**From:** Christopher Fraser <Christopher.Fraser@planning.nsw.gov.au>  
**Sent:** Monday, 31 May 2021 9:54 AM  
**To:** Grant Harlow  
**Subject:** S29/3/97-Mod-1 - Eastern Creek Karts, Departments design comments  
**Attachments:** Endeavour Energy.pdf

Following on from our discussions on design requirements on 26<sup>th</sup> and 28<sup>th</sup> May 2021 for the above please see the following notes for design work ;-

PLAN TO BE PRINTED IN COLOUR

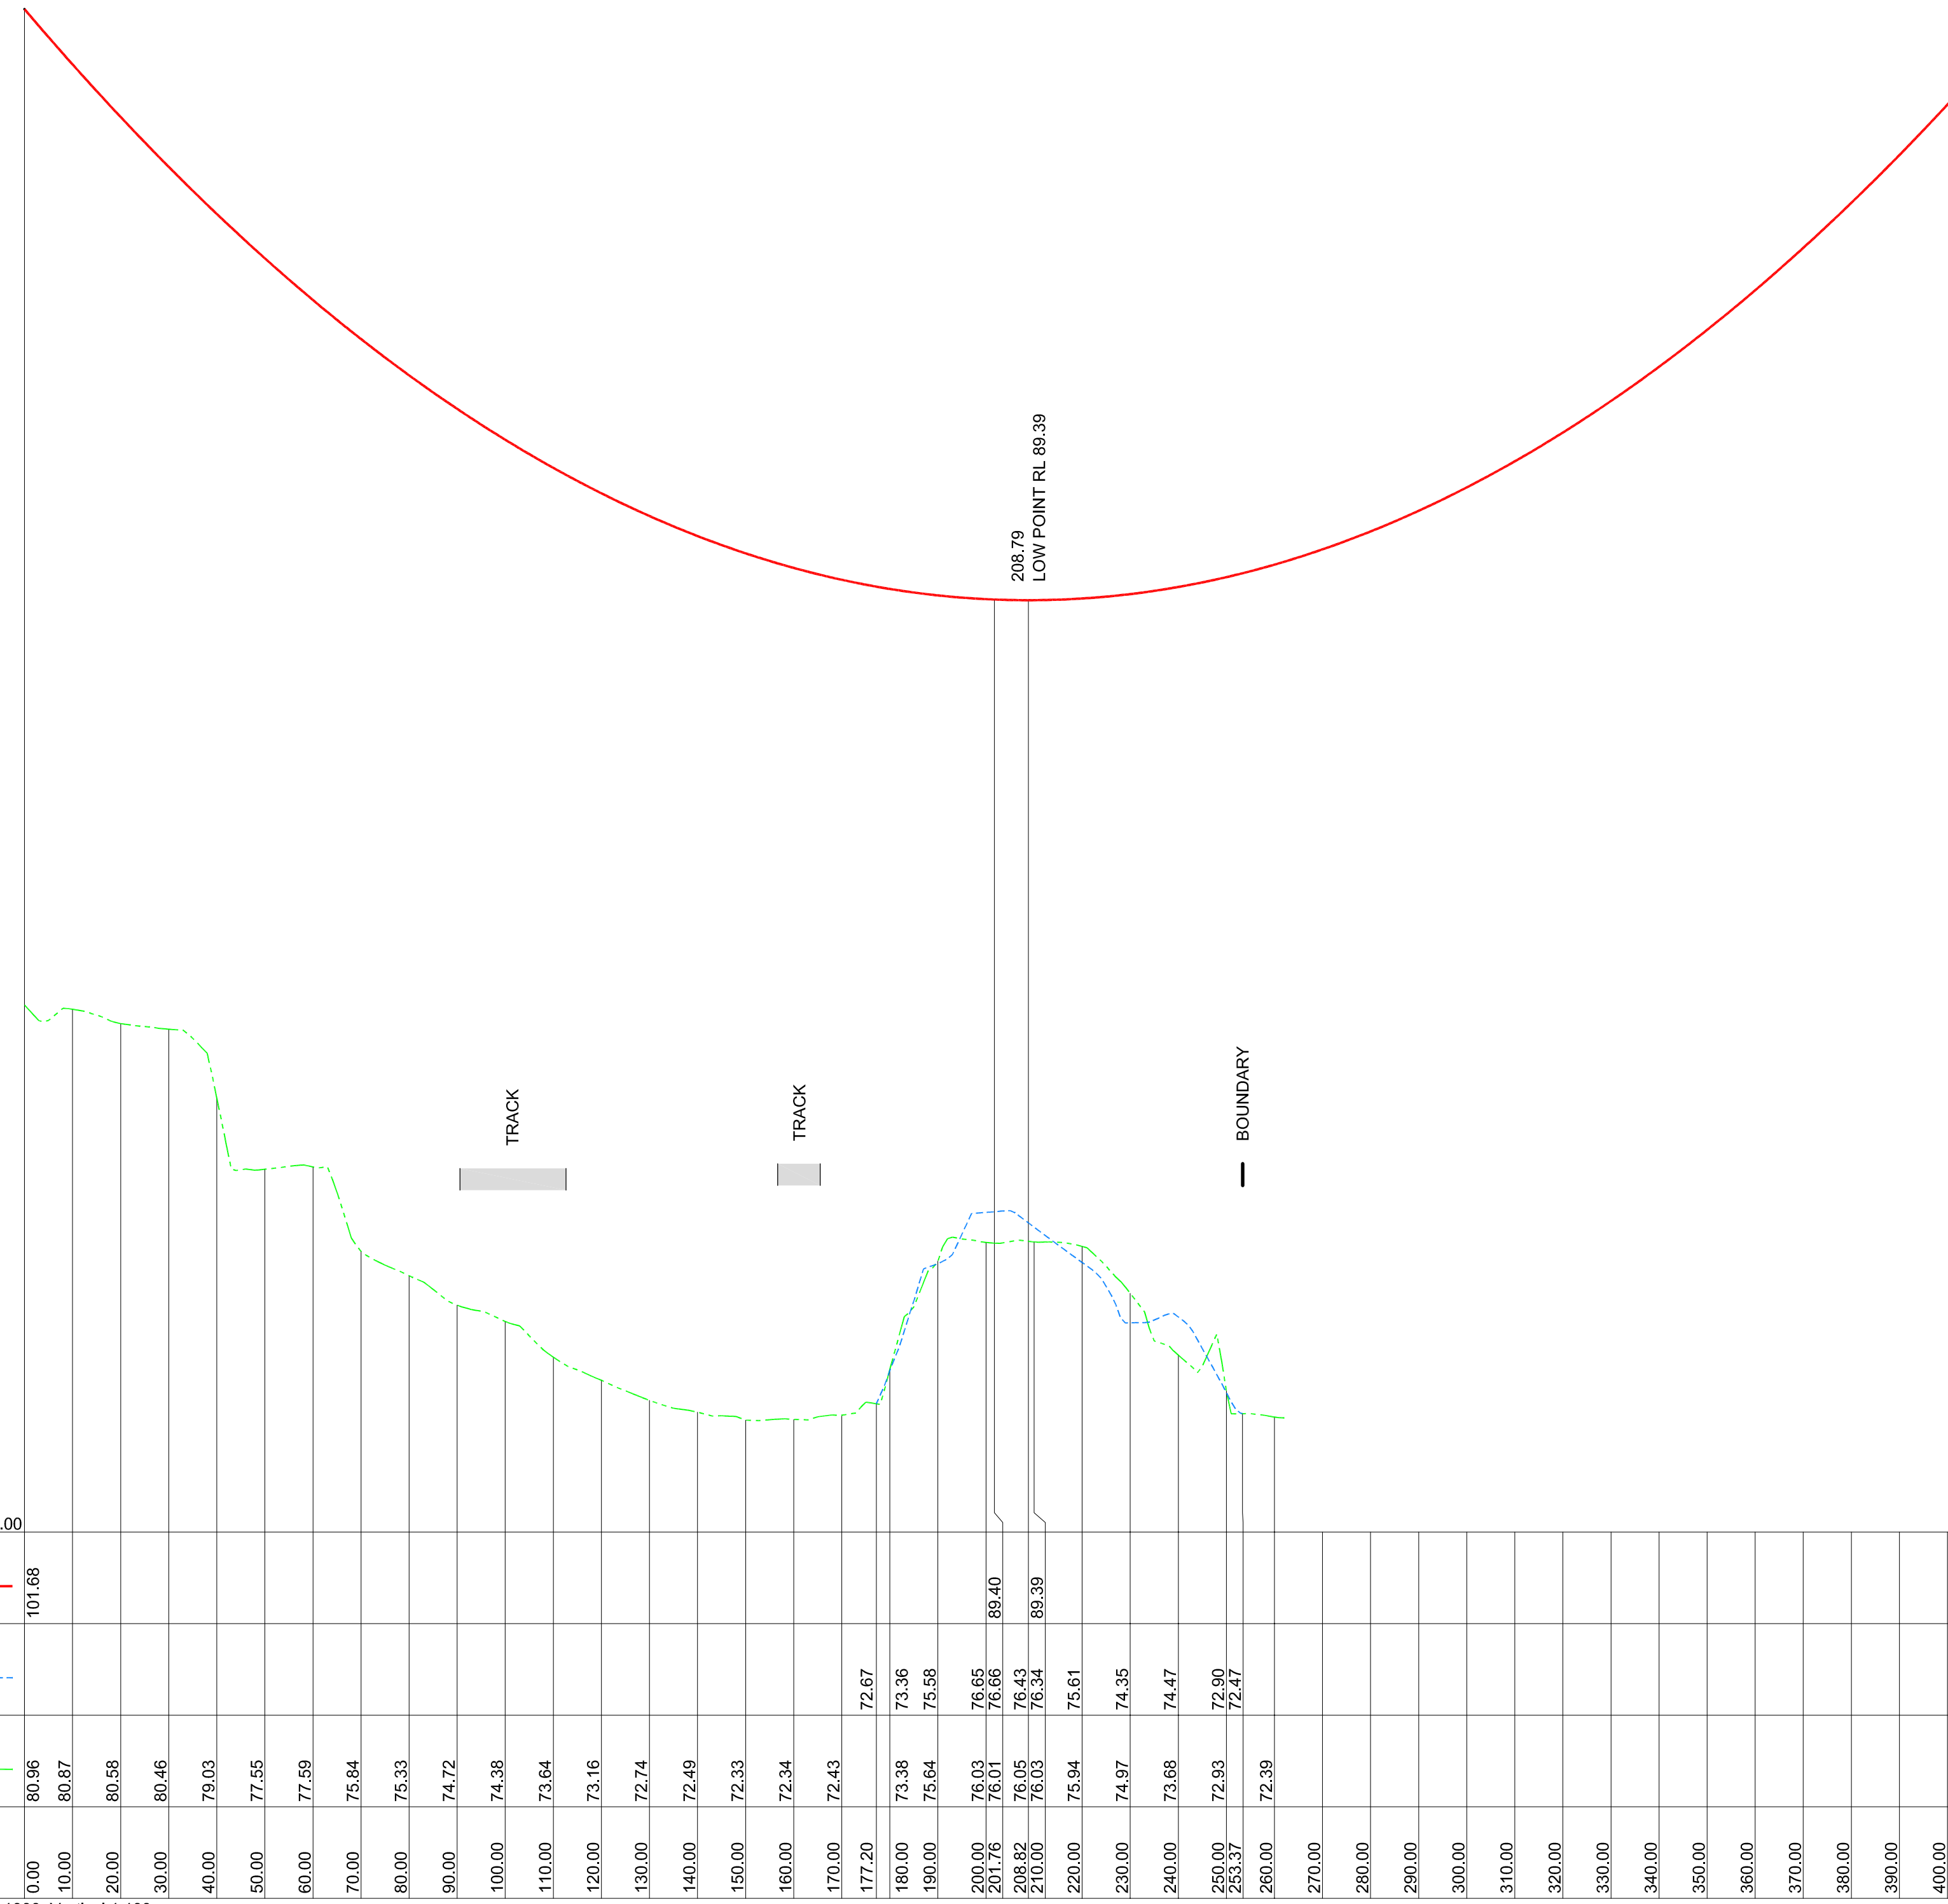
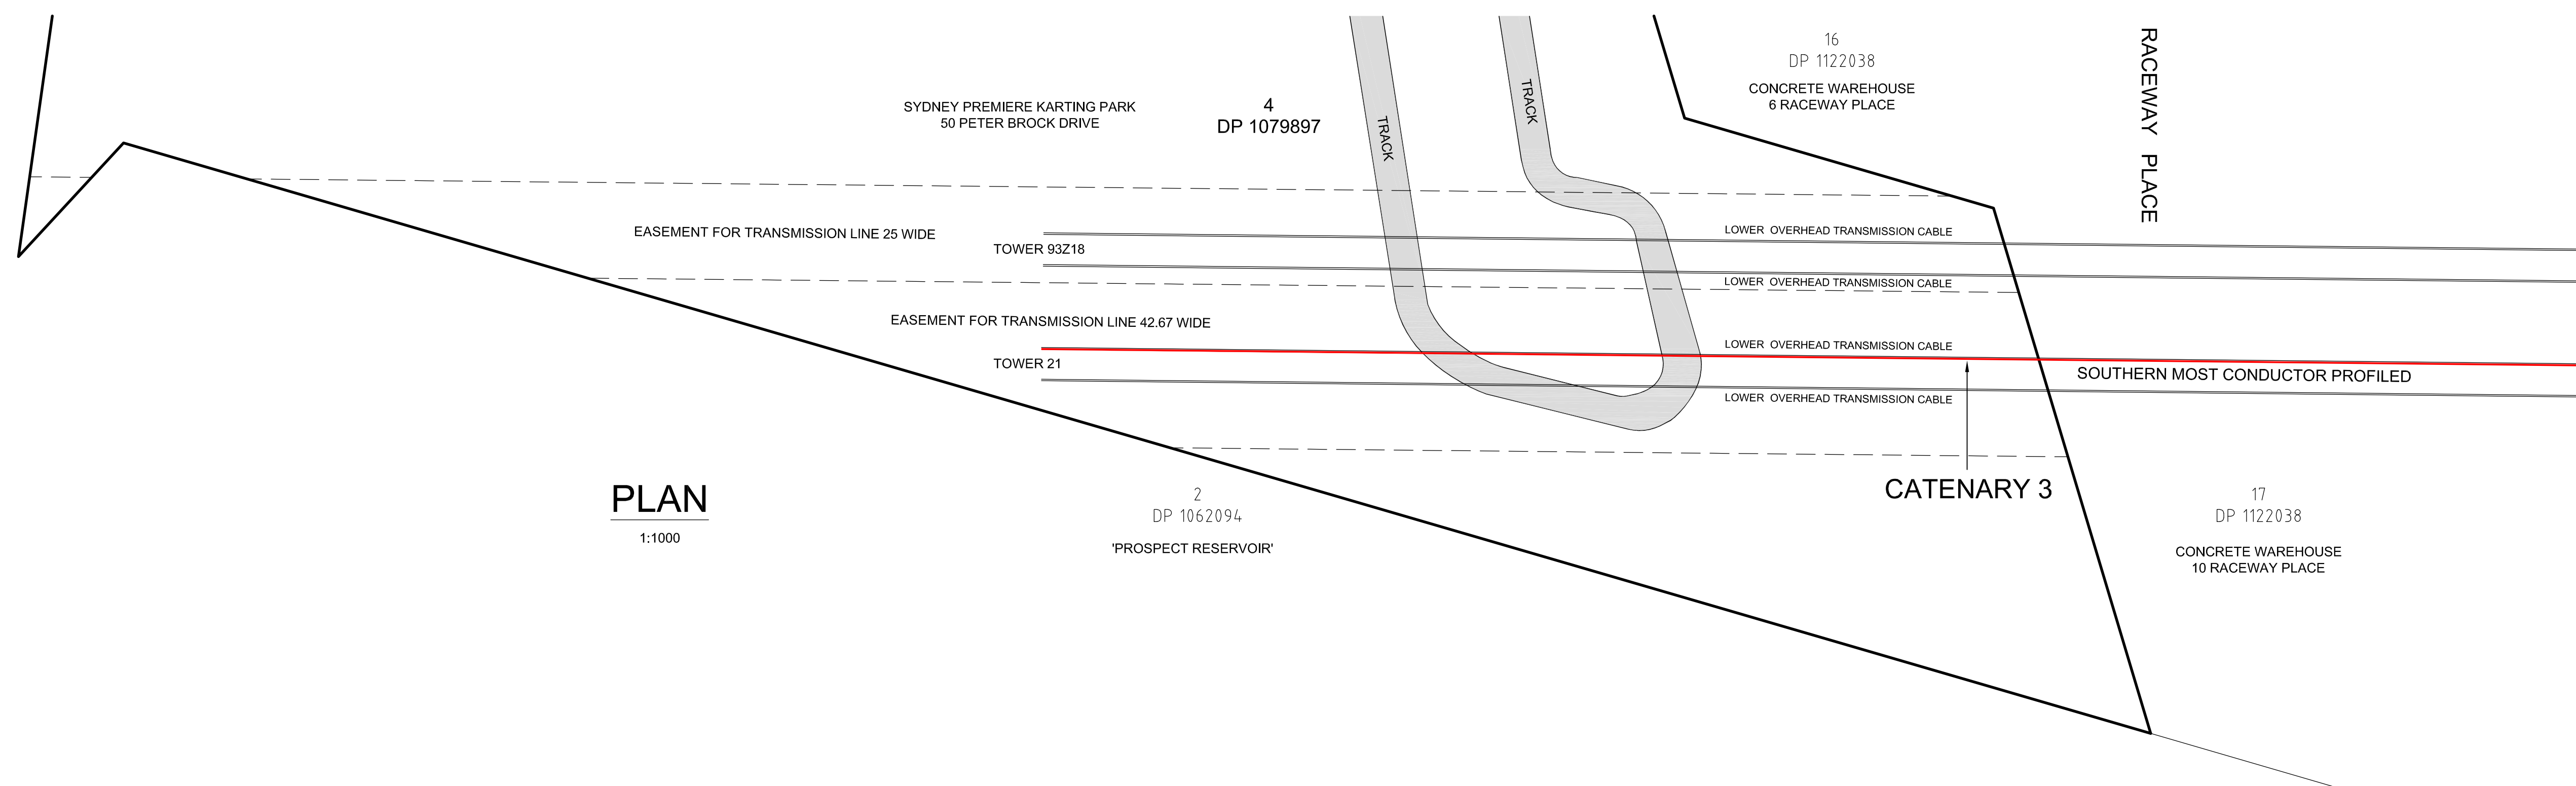
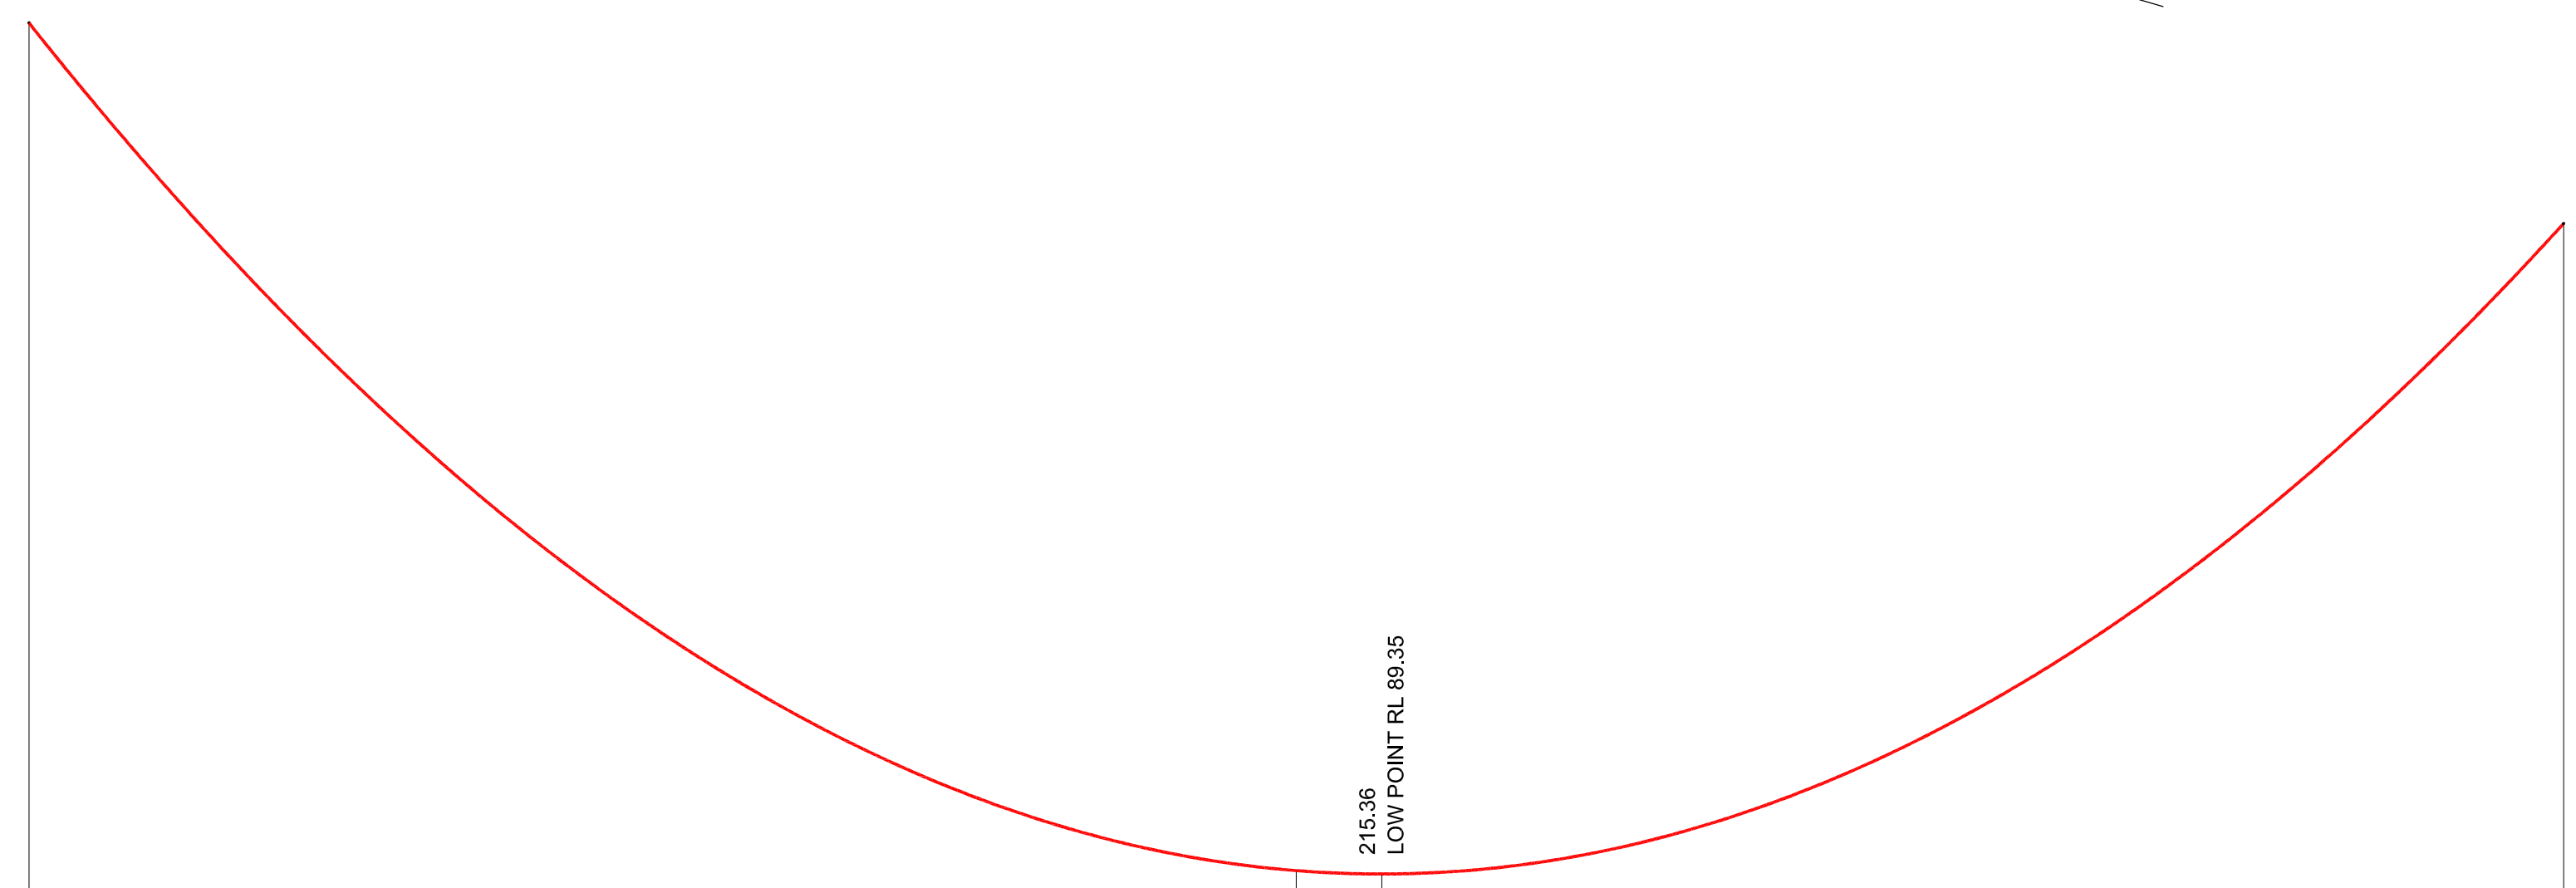
2. The vehicle's design height should be ascertained to ensure EE is satisfied with vehicle height, fill height, and consequent clearances to aerial conduits to prevent arcing.
